6 November 2013

Name: MAXIA SOAPY
Address: 123 Abercrombie
ST
Chippendale

**Modification Request for the University of Sydney Abercrombie Precinct
Redevelopment: Application Number: MP07_0158 MOD 3**

Ground Floor Plan
1:200@A1
11.10.13
4001_DA02-D

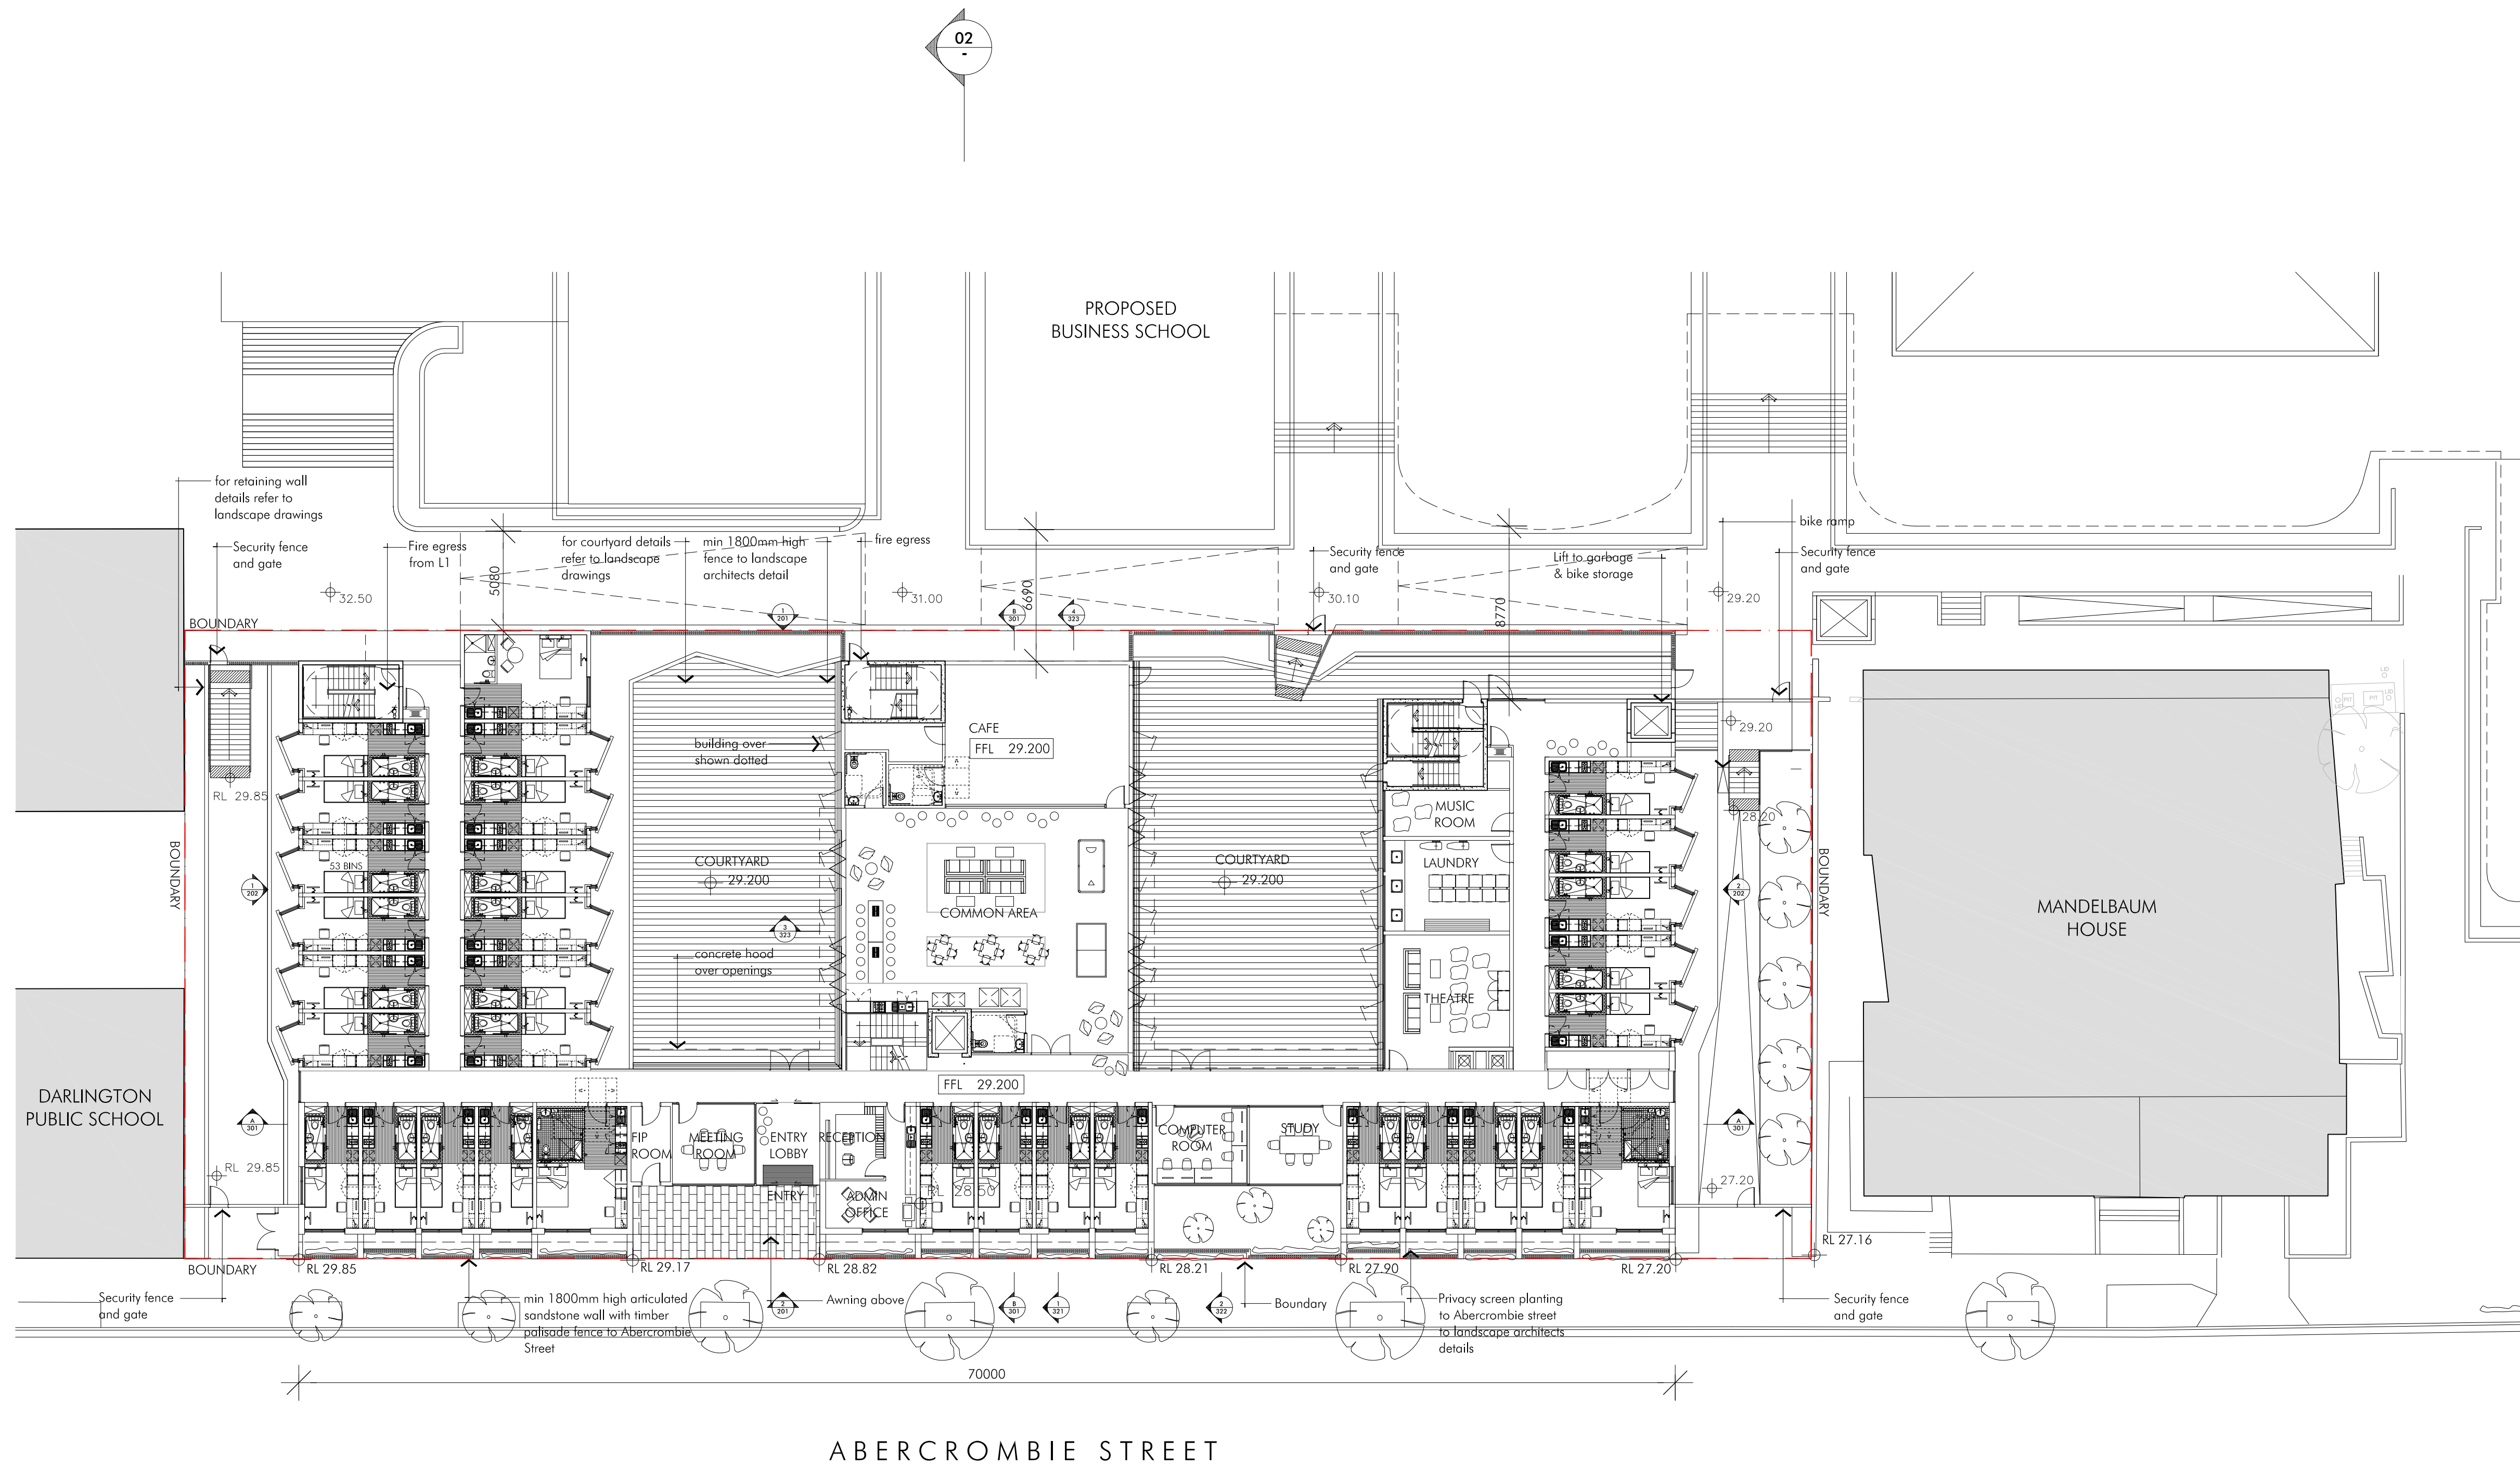
- The front of the Student Accommodation building should be built 2 metres back from the Abercrombie Street boundary. It should be set back from this boundary so that it is in line with Mandelbaum House as it was originally planned and presented to the community. The footprint of the buildings currently on the site, The Shepherd Centre and Boundary Lane Children's Centre, were built approximately 2 metres back from the Abercrombie Street boundary and align with Mandelbaum house. Therefore, the front footprint of the proposed Student Accommodation building should be the same as those buildings occupying the site at present and not be built up to the Abercrombie street boundary.

02 ELEVATION SOUTH (ABERCROMBIE STREET)
SCALE 1:200

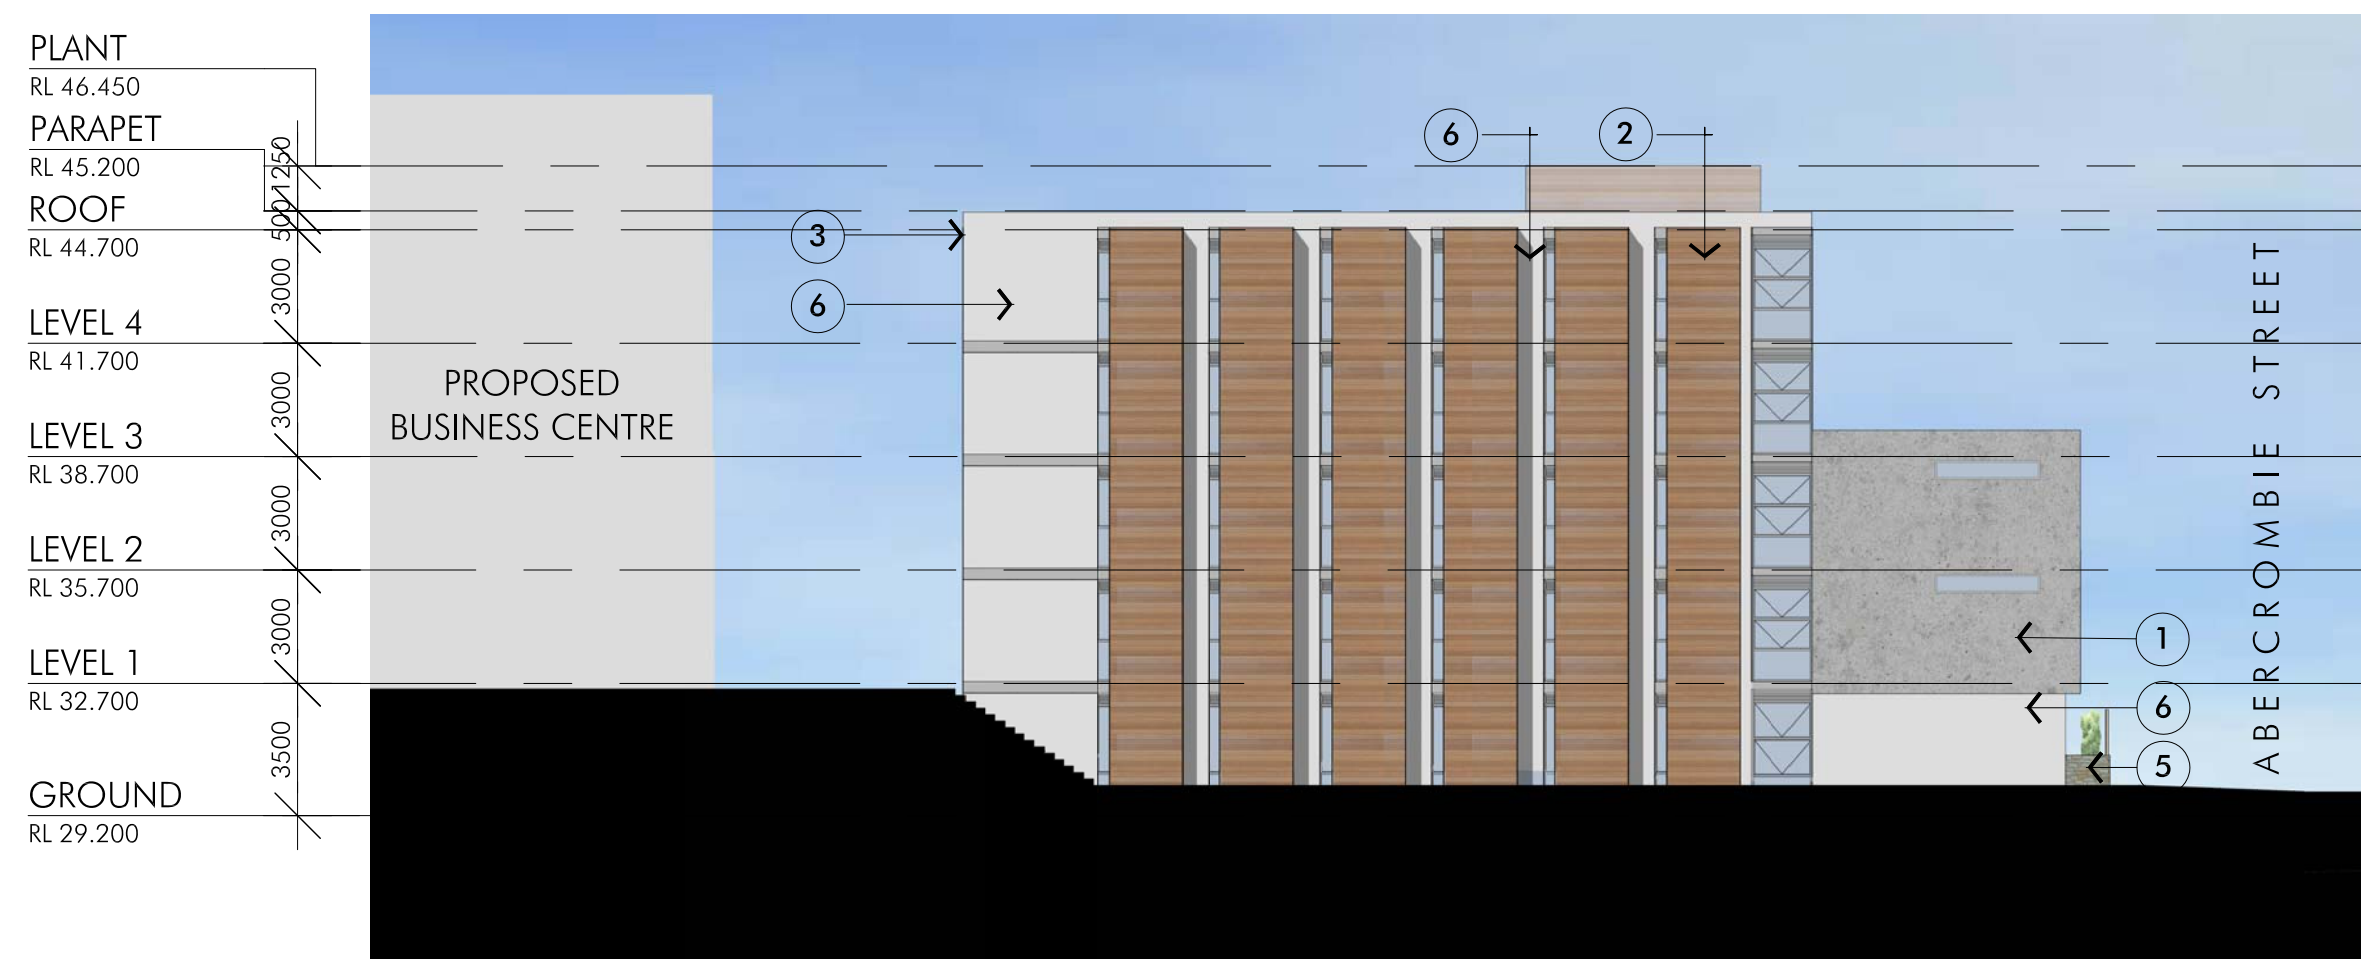
- The facade of the proposed Student Accommodation building does not reflect the heritage appearance of the Victorian terraces on Abercrombie Street as Mandelbaum House does. Therefore, it should be set back to allow for extensive vegetation and trees to be planted in front of the building on Abercrombie Street to help preserve the heritage streetscape and improve both the aesthetics and the environment of the street.
